**COMMUNITY SERVICES DEPARTMENT**

November 23, 2021

**Subject: Sand Creek Channel Design and Construction Documents, Review #3 (CDR-20-004)**

C204

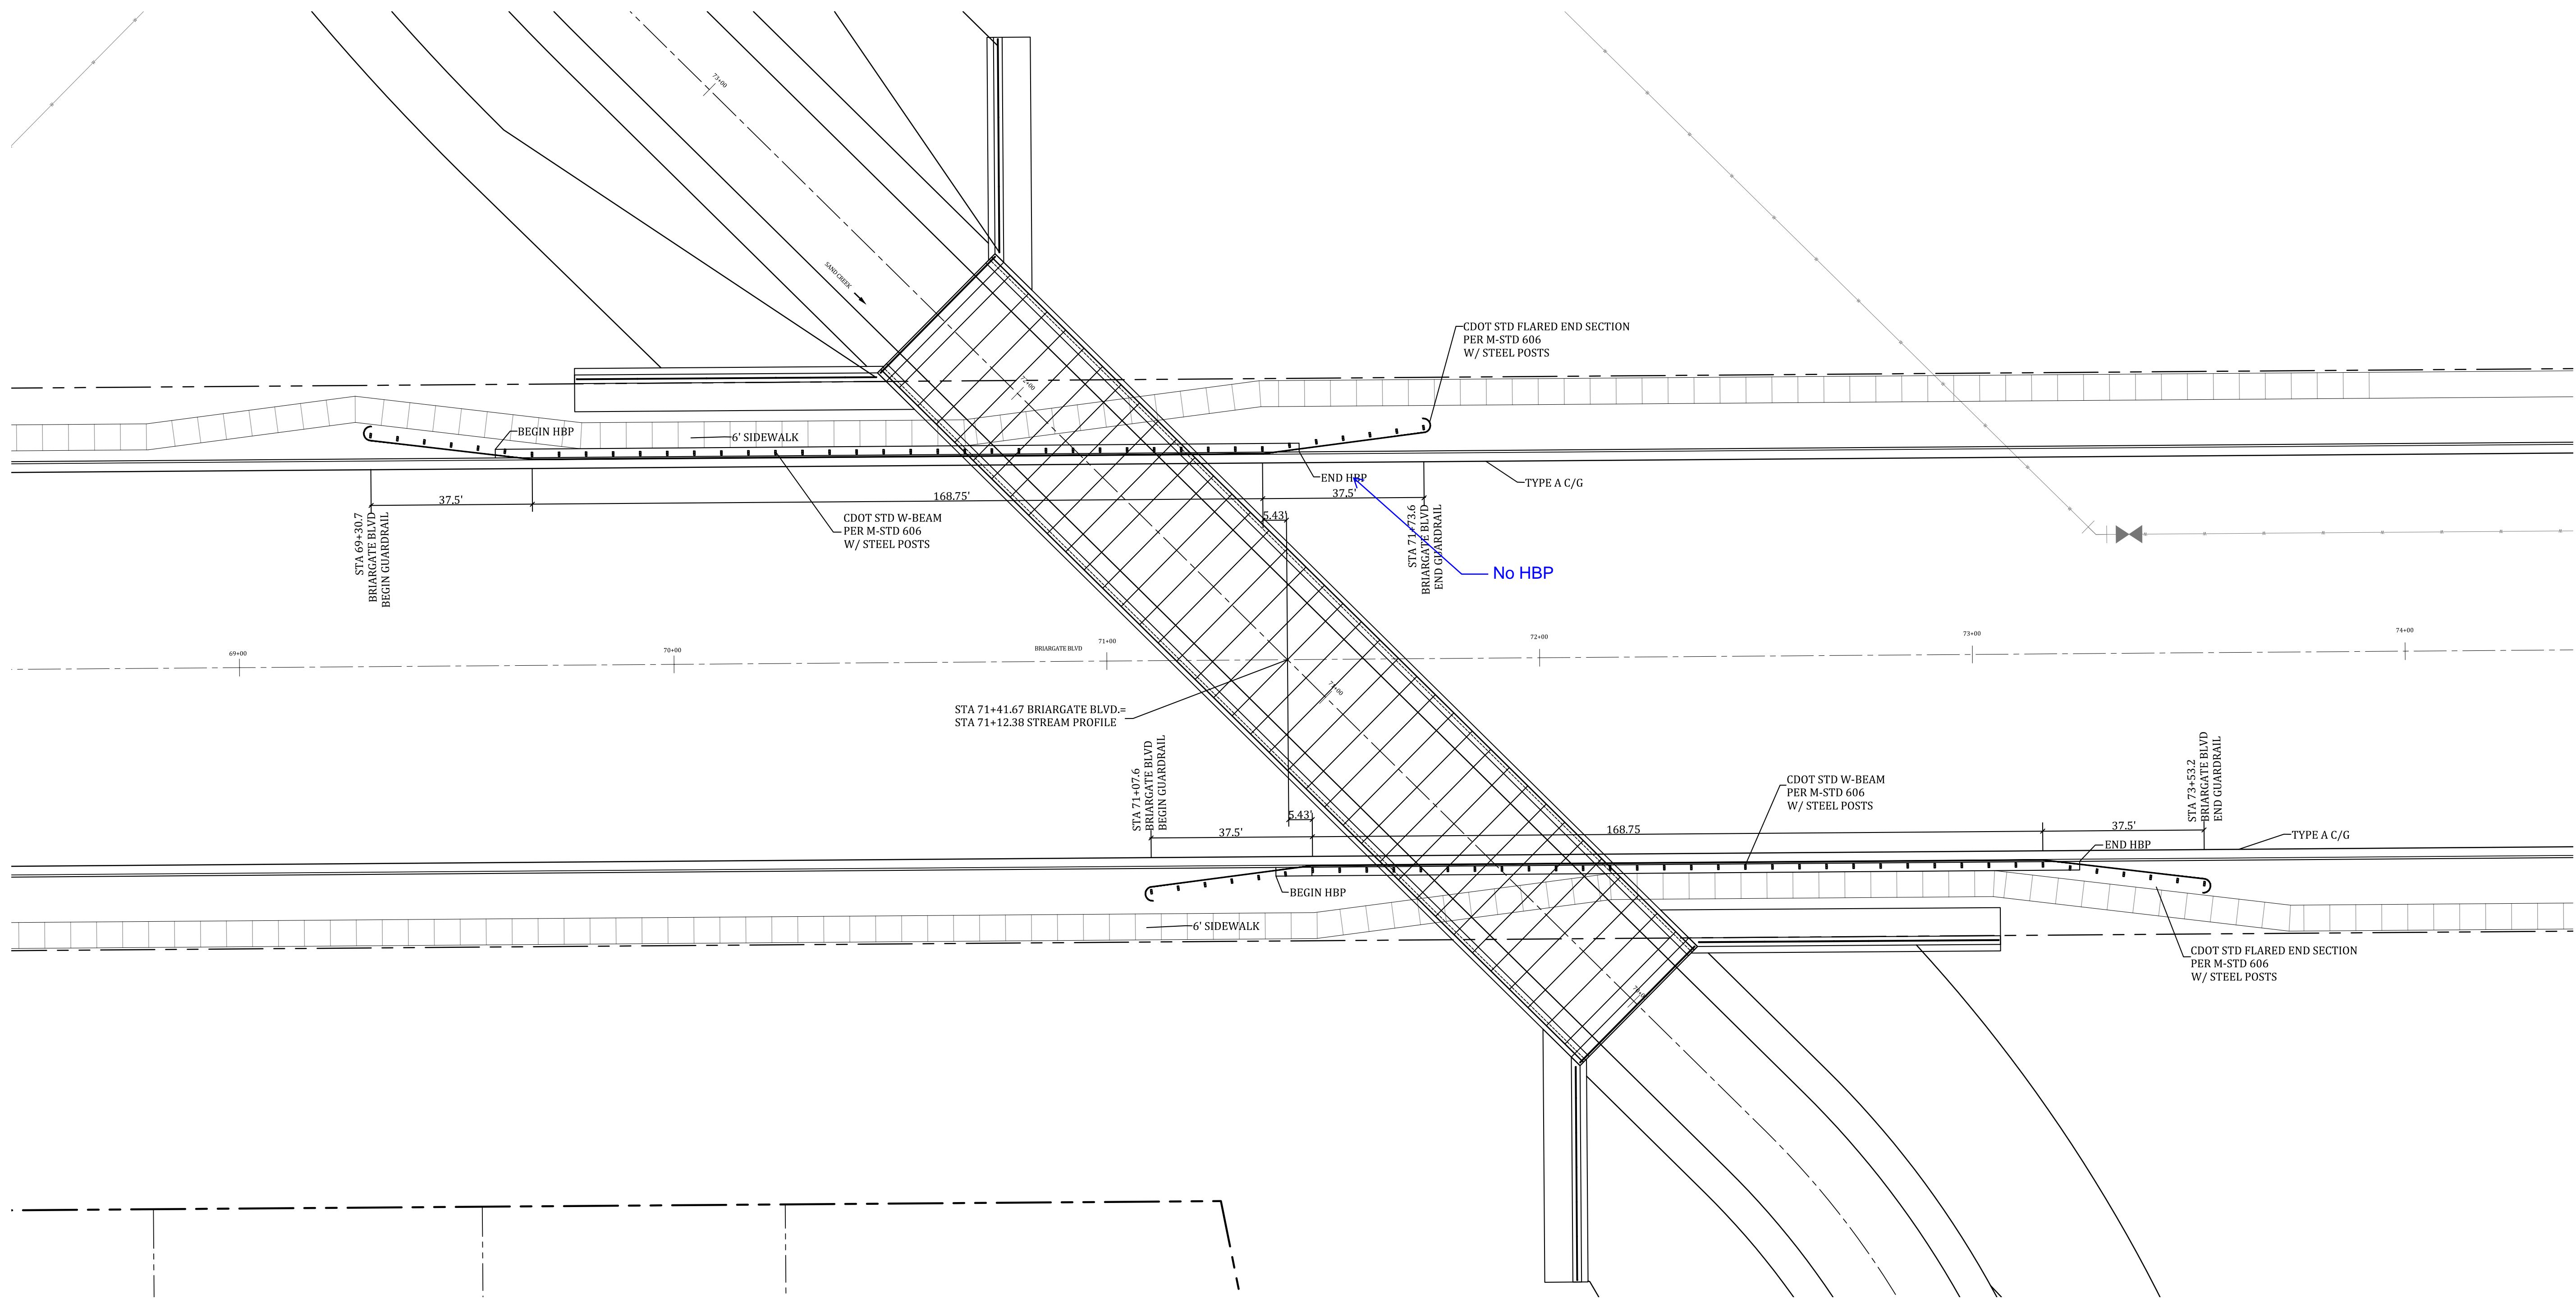
*Pages C202 and C204 of the Construction Documents show the Briargate Boulevard Bridge design, including the locations of the proposed 6-foot wide sidewalk and guardrails, while a detail on C222 provides the general cross-section for the guardrail and sidewalk on either side of the bridge. Staff understands the constraints of routing the previously recommended 10' concrete sidewalk and 5' gravel trail across the bridge, between the wingwalls and guardrails for Briargate Boulevard, and further recognizes that certain aspects of the sidewalk and adjacent gravel trail may need to be modified and possibly narrowed within the bounds of the bridge structure. Staff recommends the applicant and designers show the approaches of the sidewalk and adjacent trail on the C202 or C204 layouts."*
